Our reference: SF16/21988, DOC17/362364

ToxFree Australia Pty Ltd 40 Christie Street St Marys
Modification of an Existing Activity - Acid Alkali Neutralisation Plant - MP06_0095 MOD3.

I refer to your correspondence dated 14 June 2017 and the attached document 'Acid Alkali Neutralisation Plant Air Quality Impact Assessment, Report No 610.16735-R02', dated 12 June 2017 prepared by SLR Global Environmental Solutions.

Figure 13 Predicted Ground Level 99.9th Percentile Chlorine Concentrations

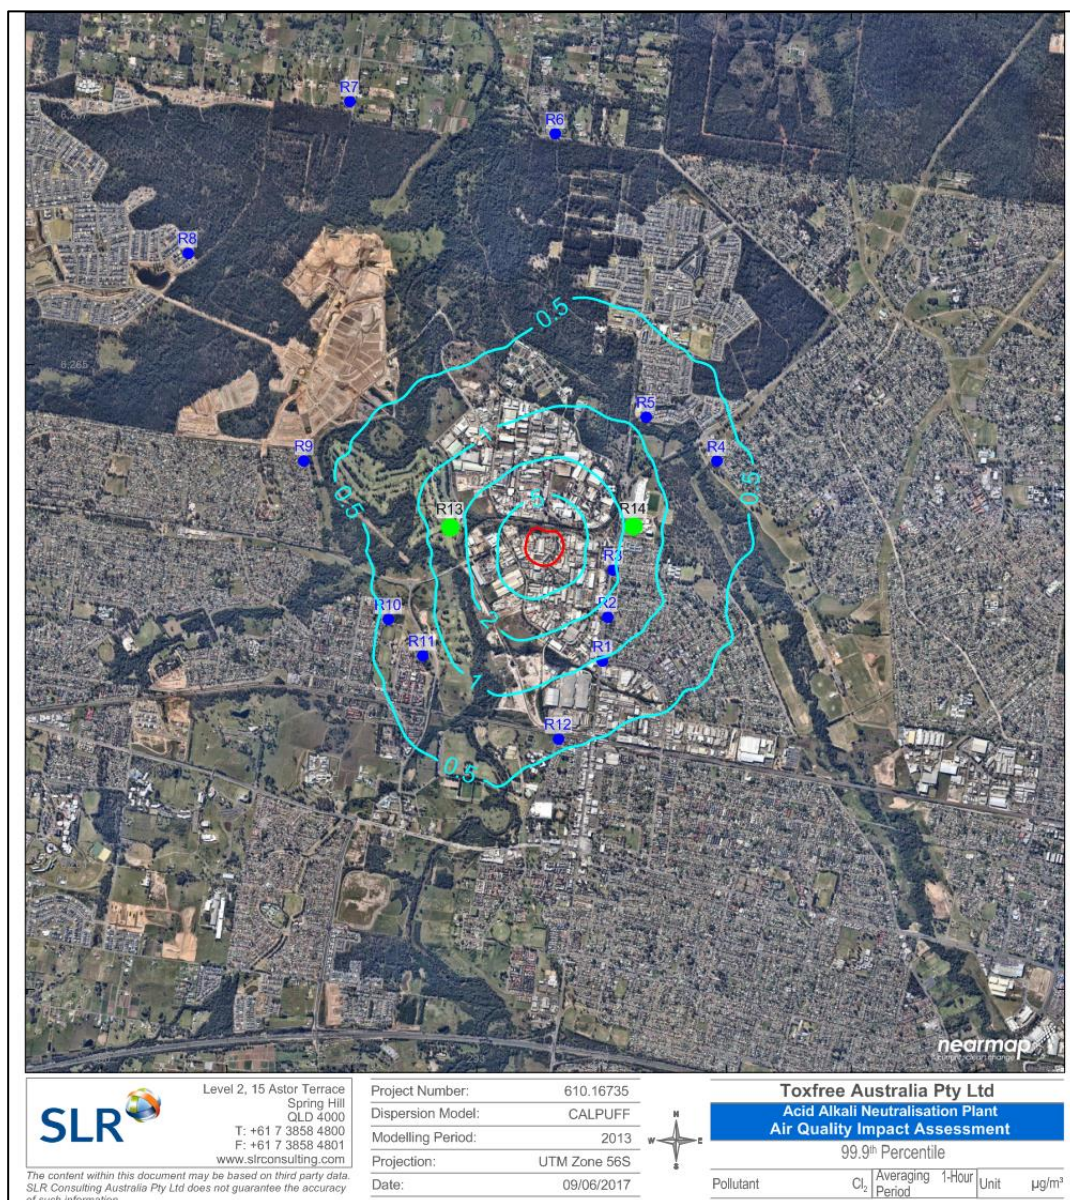
- Predicts ground level concentrations for SO₂ and Cl₂ utilising the Calpuff dispersion model;
- Predicts ground level concentration for Chlorine above the impact assessment criteria beyond the site boundary. As per the Approved Methods for Modelling and Assessment of Air Pollutants in NSW, the impact assessment criteria apply at and beyond the site boundary;

Chlorine maybe above the prescribed concentrations contained in the Clean Air Regulation; and

- There is likely to be some conservativeness in the emission estimation, as it is assumed that complete reaction occurs between the process inputs, which may not necessarily happen in reality; and
- There is uncertainty with the proposal in complying with the Clean Air Regulation and the impact assessment criteria for chlorine.

- Information is required to demonstrate that the proposal can be designed and operated to:
 - a. Comply with the prescribed concentrations contained in the Clean Air Regulation;
 - b. Comply with the impact assessment criteria for chlorine at or beyond the site boundary.

1. The proponent provide information to demonstrate compliance with the Clean Air Regulation. This could include:
 - a. Emission guarantees or manufacturers specifications to demonstrate compliance with the Clean Air Regulation;
 - b. The nomination of an emission limit, that the emission controls will achieve, and will meet the Clean Air Regulation;
2. Revise the Air Quality Impact Assessment to demonstrate that the proposal can be designed and operated to comply with the ground level concentrations for chlorine at or beyond the site boundary, based on a proposed concentration limit.
